**Flood and Water Management**  
Invicta House  
Maidstone  
Kent  
ME14 1XX  
**Website:** [www.kent.gov.uk/flooding](http://www.kent.gov.uk/flooding)  
**Email:** [suds@kent.gov.uk](mailto:suds@kent.gov.uk)  
**Tel:** 03000 41 41 41  
**Our Ref:** SBC/2023/093697  
**Date:** 30 January 2023

**Application No:** 22/505852/SUB

**Location:** Land Off Staple Street Hernhill Kent ME13 9HY

**Proposal:** Submission of Details Pursuant to condition 14 (Surface Water Drainage Scheme) of Application 20/503666/FULL.

Drawing Number: **65204882-SWE-ZZ-XX-DR-C-0100**

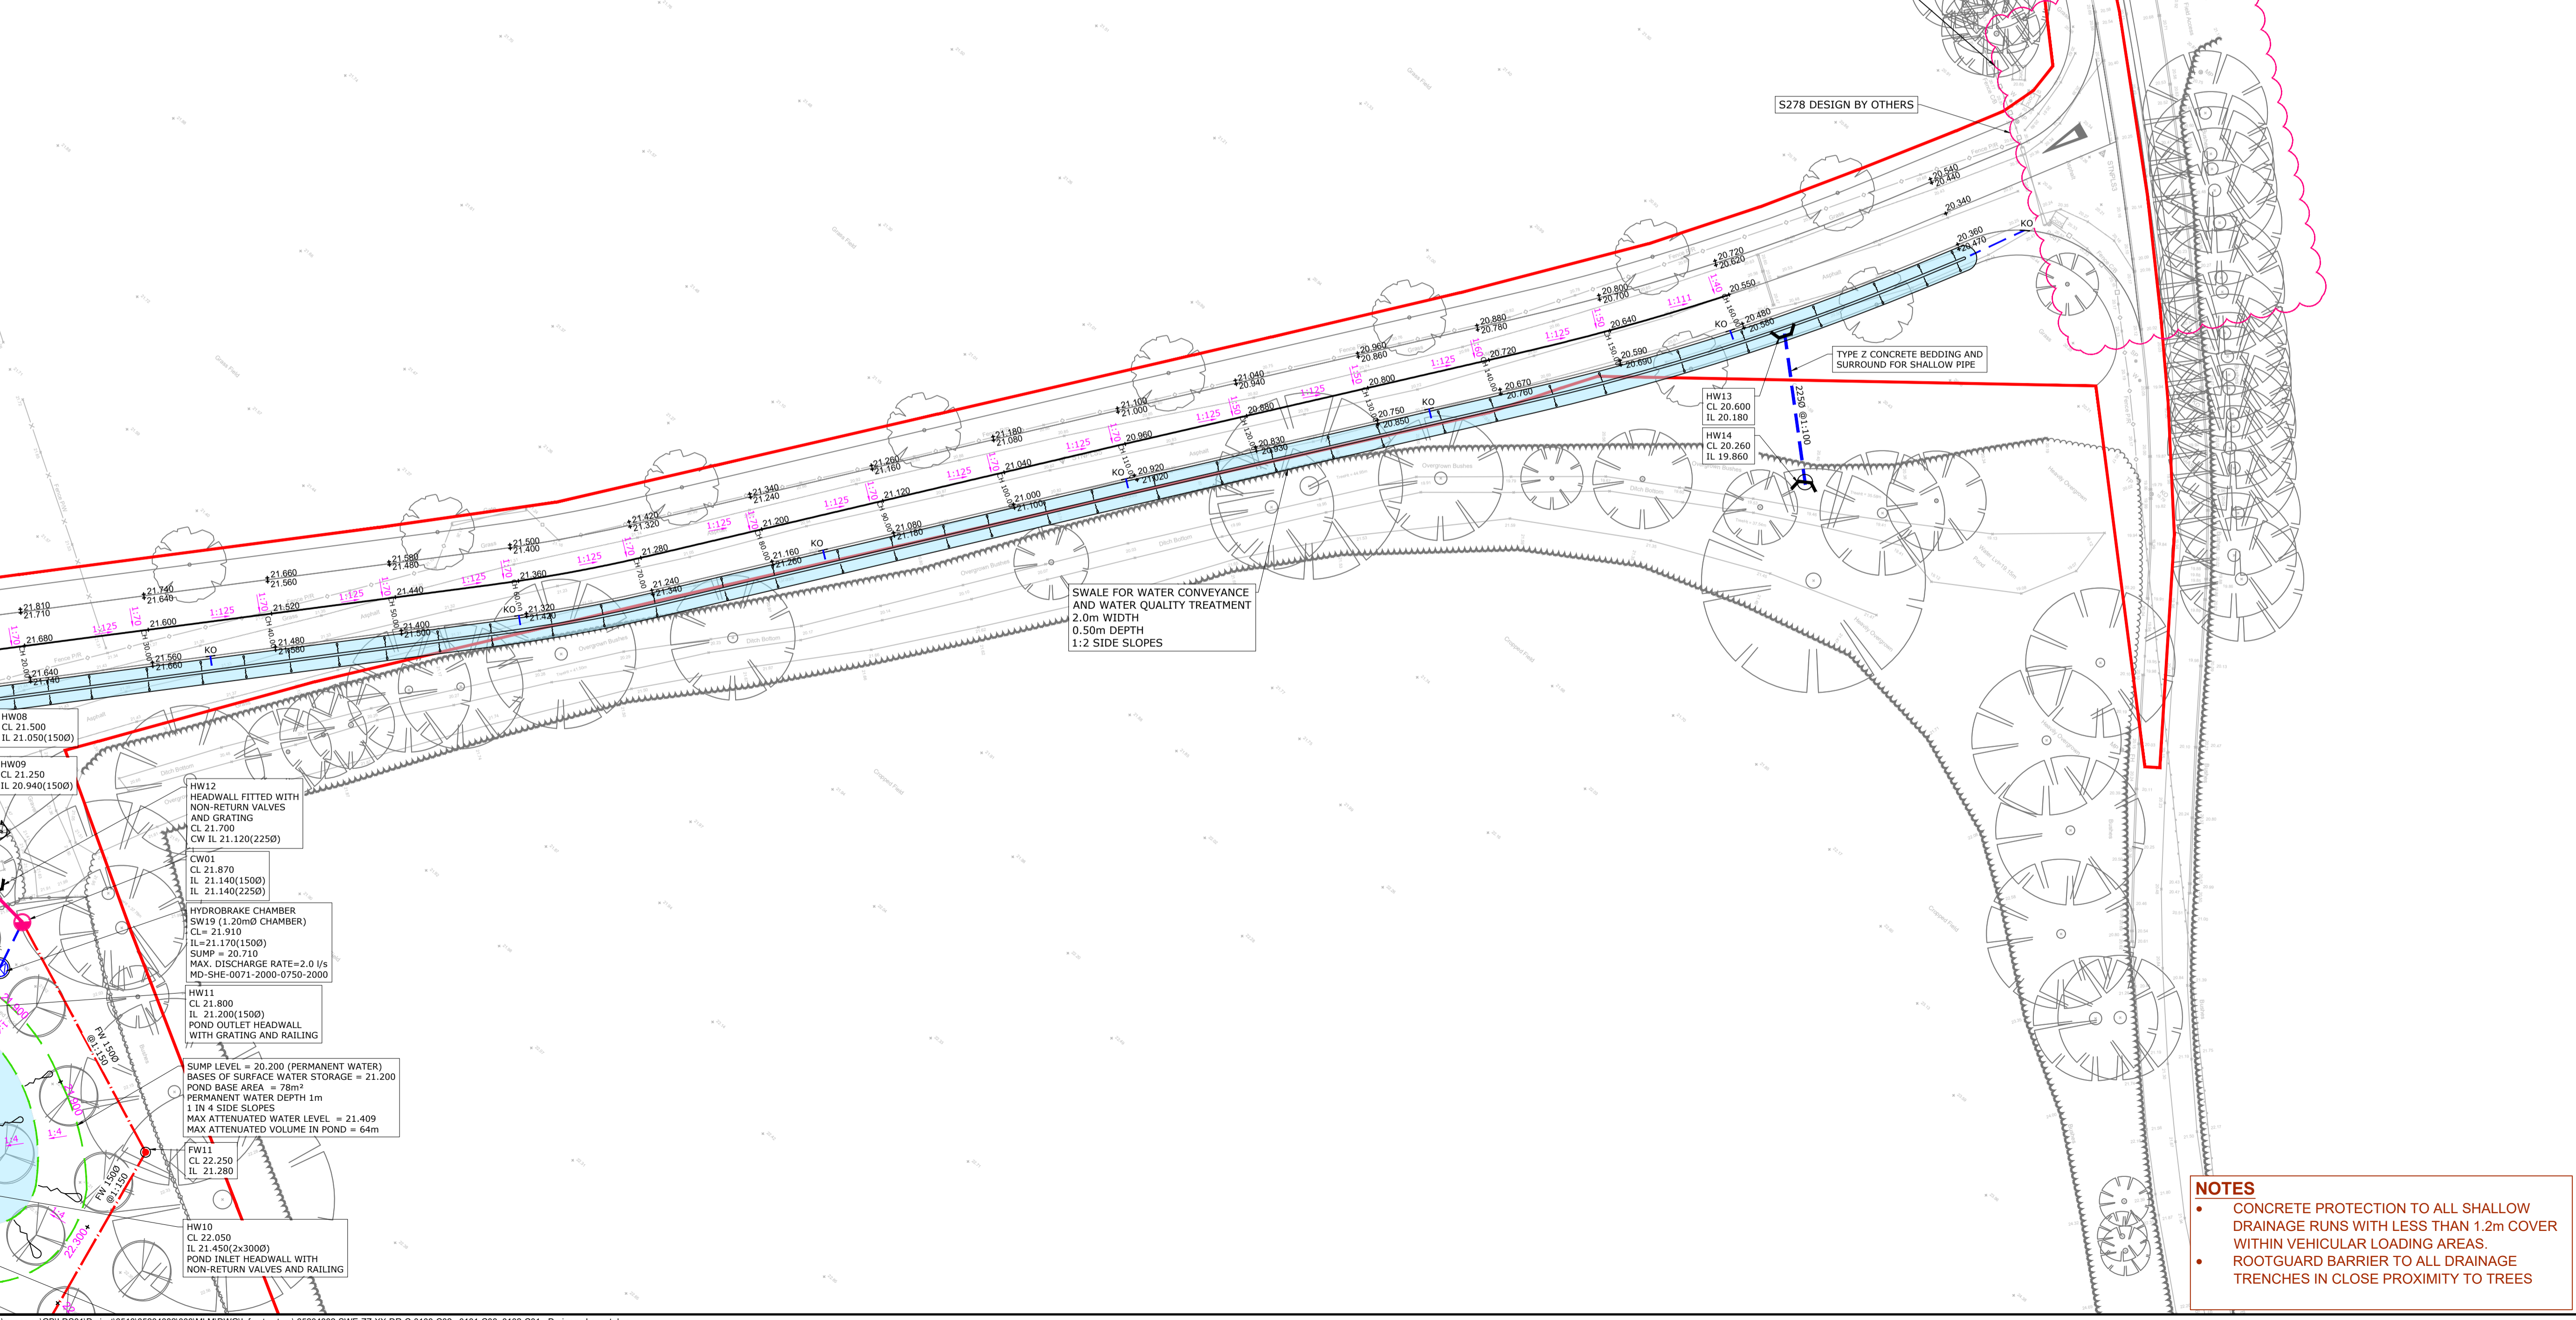
1. We note that the discharge rate previously approved on the 15th December 2020 was 2 l/s from the site. Drainage Layout Sheets 1 and 2 (65204882-SWE-ZZ-XX-DR-C-0100 and 65204882-SWE-ZZ-XX-DR-C-0101) now provided, appear to show three further points of unrestricted discharge into the ditch. We would expect discharge from the whole site to be restricted to 2 l/s as previously approved unless it can be shown that discharge rates from the site are not exceeding greenfield rates for their respective storm events or QBAR.

2. In addition to point one above, it is noted a package treatment plant is provided onsite to treat foul water prior to discharge into the watercourse. With this addition of flow there is concern that the rates entering the ditch is now above greenfield rates and as such could result in increase flood risk downstream.
